# **Comments appertaining to ESSO's response to RBC's written representations 1 (Deadline 2)**

**Application by ESSO Petroleum Company Ltd  
for an Order Granting Development  
Consent for the Southampton to London  
Pipeline Project**

**Application Reference EN070005**

**Internal Reference 19/00432/PINS**

S2700-T284-C2 – Tree number and category

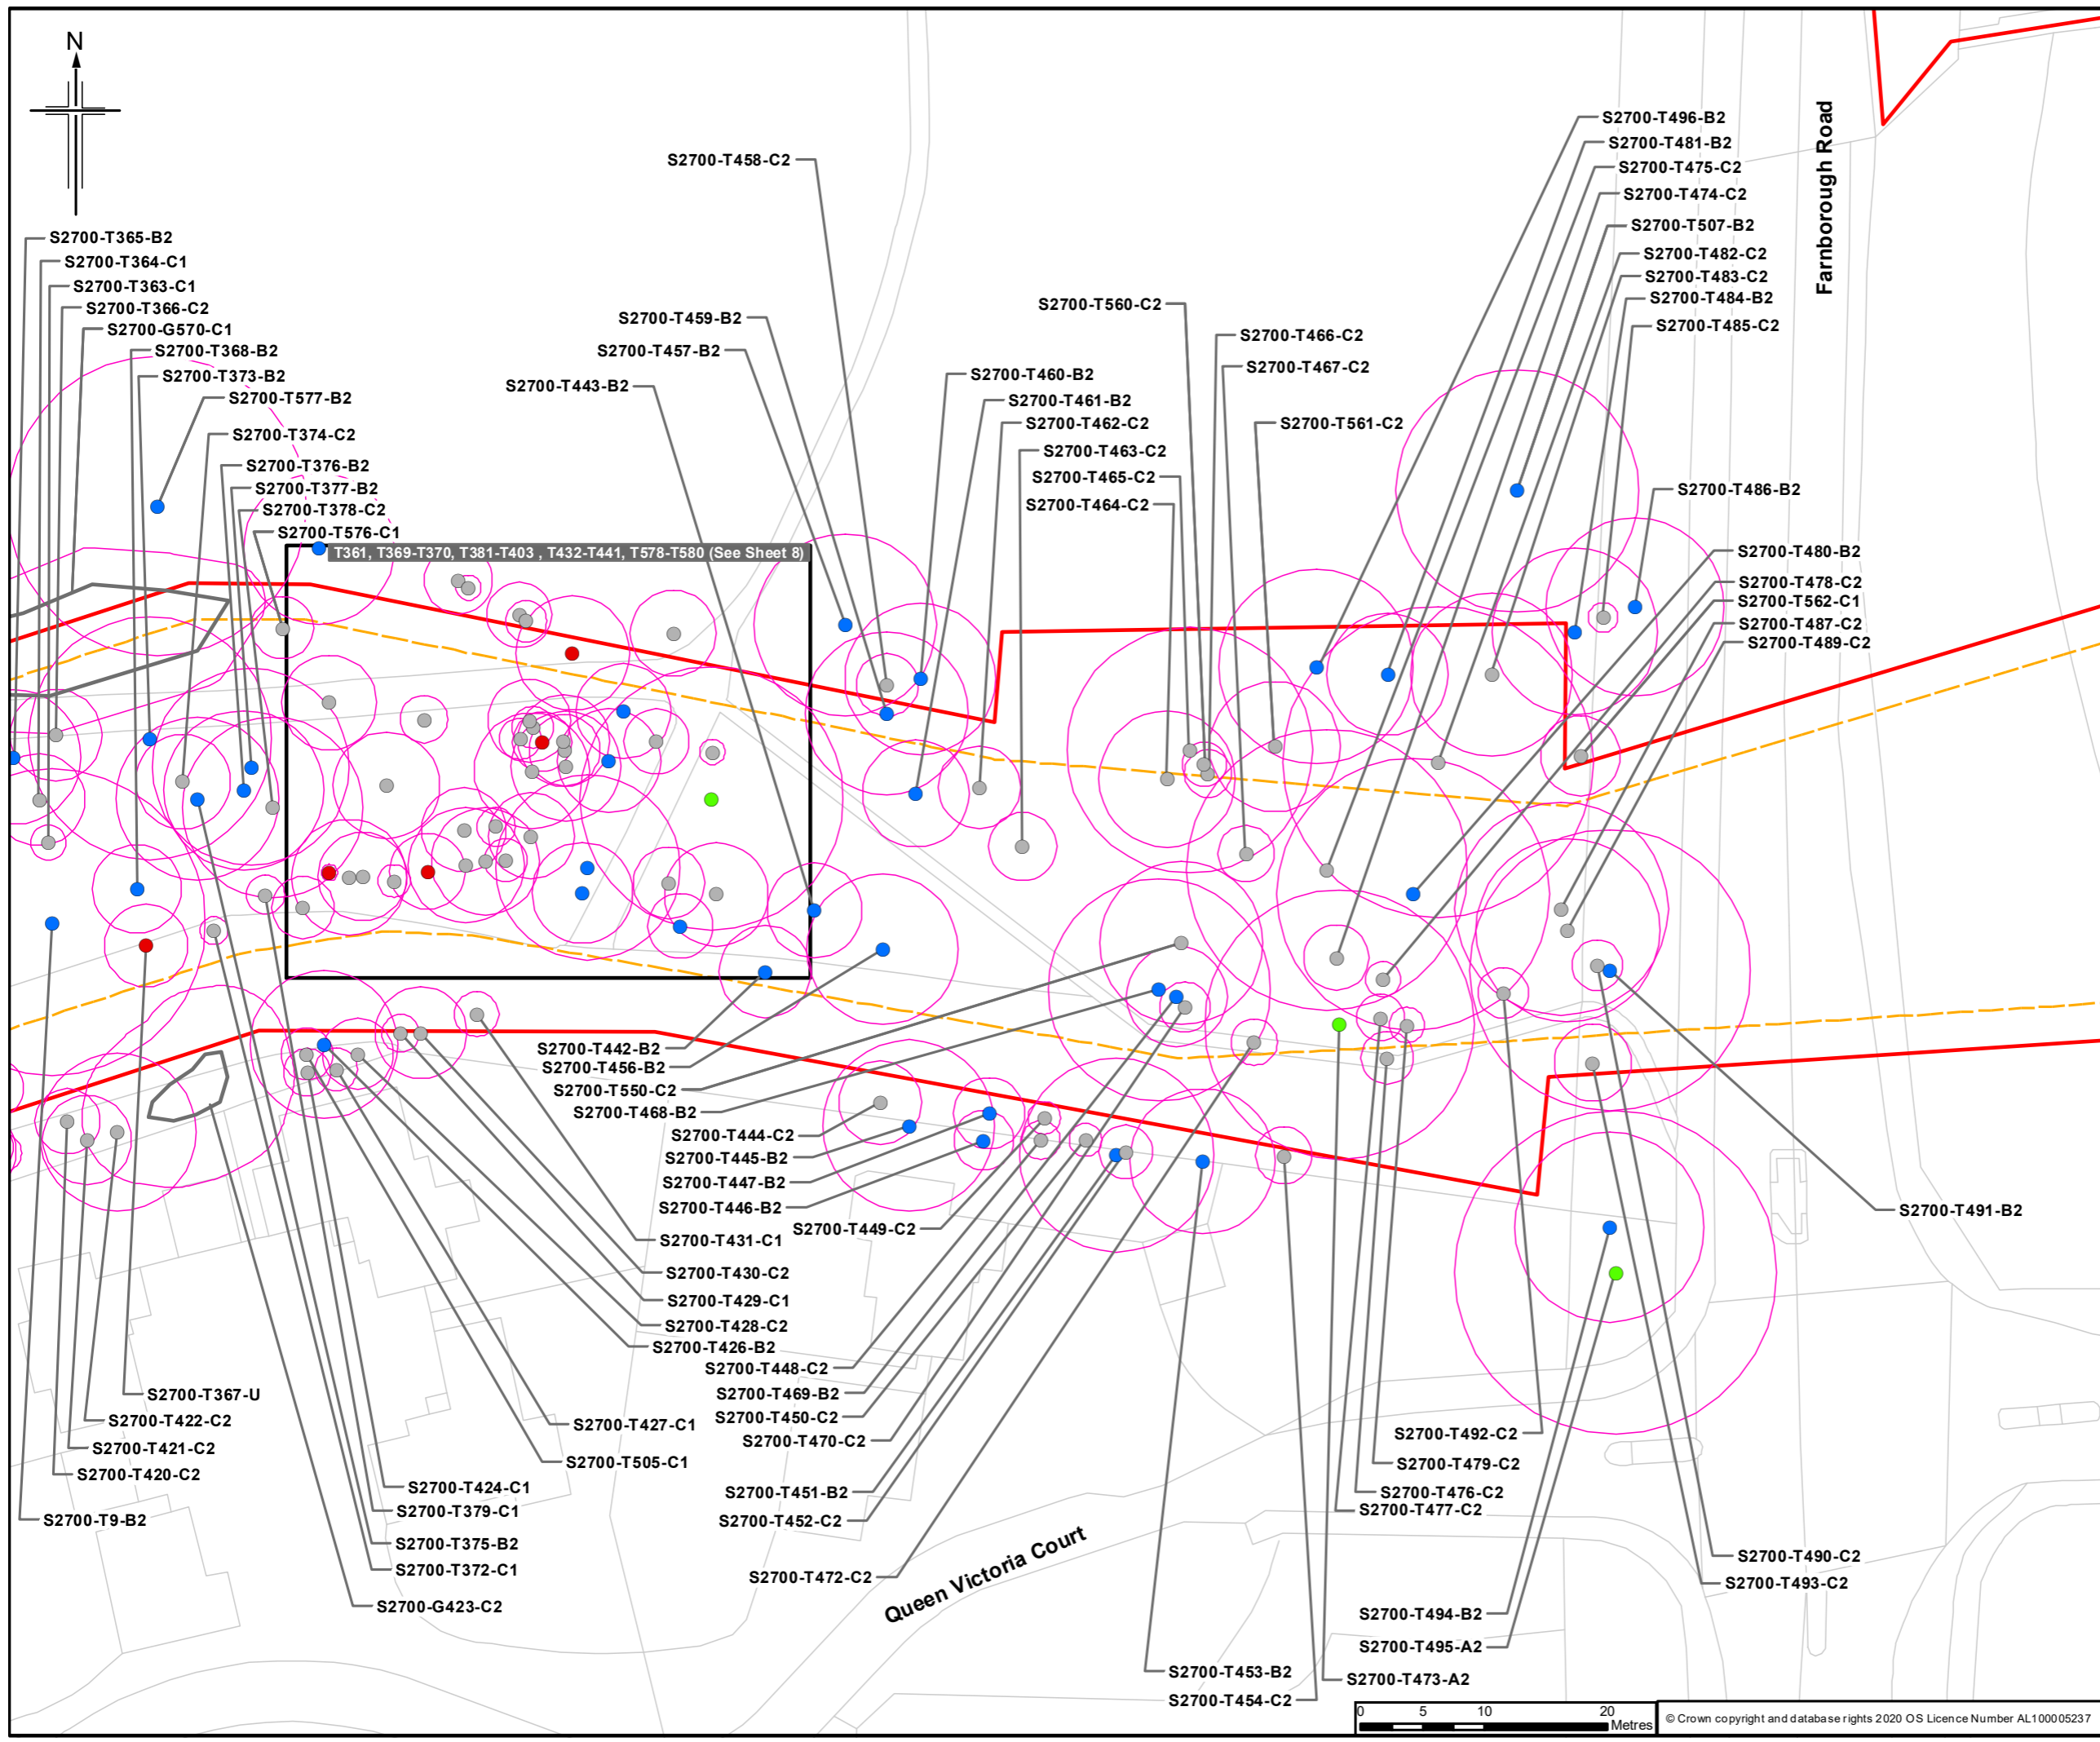
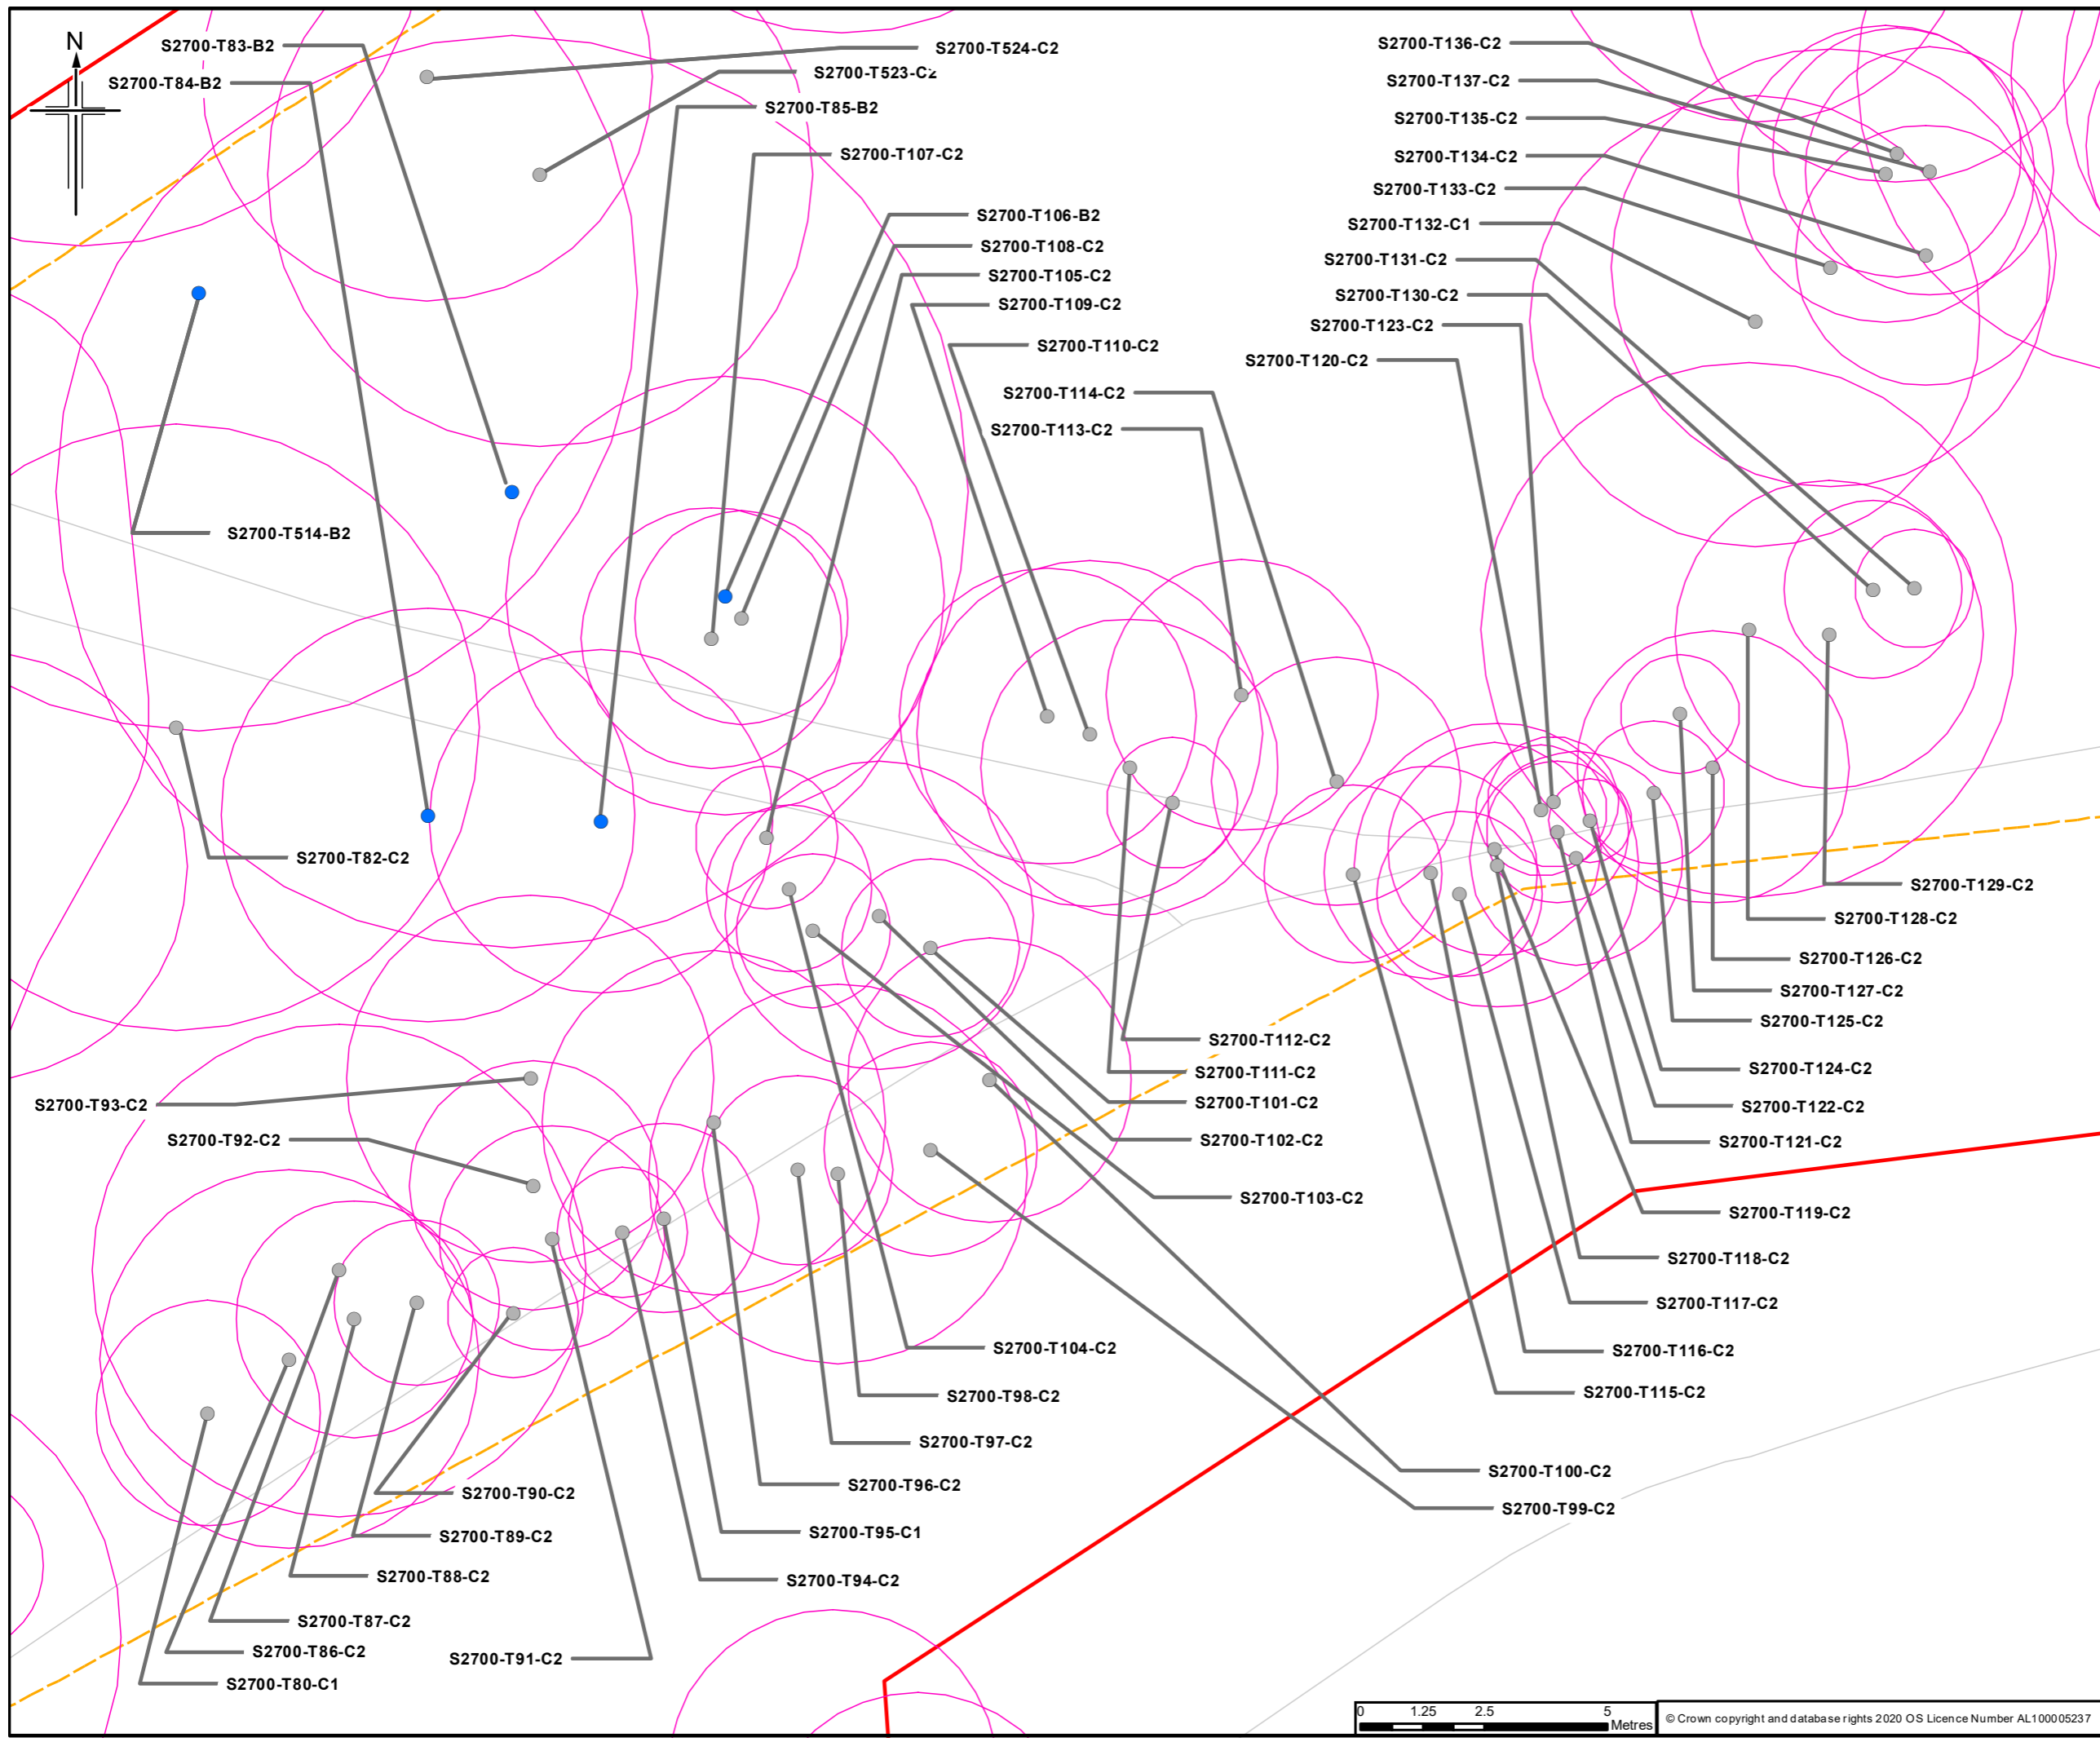
- 4.4 In respect of Queen Elizabeth Park the council would have expected this site to be surveyed due to the significant loss of the priority mixed broadleaved deciduous woodland. However the original survey missed many notable and veteran trees and therefore their loss was not

- 4.6 The council is particularly concerned regarding the assessment undertaken within Queen Elizabeth Park. Although many trees within the order limits appear to contain bat potential, with a significant number of notable and veteran trees present within the park, only two trees were climbed. The council has agreed for ESSO to undertake further bat and tree condition surveys within QEP which RBC understands are to be submitted at deadline 4. If we still feel that the information is inadequate we intend to undertake our own survey which we will submit before the next hearings, along with comments on the next steps required.
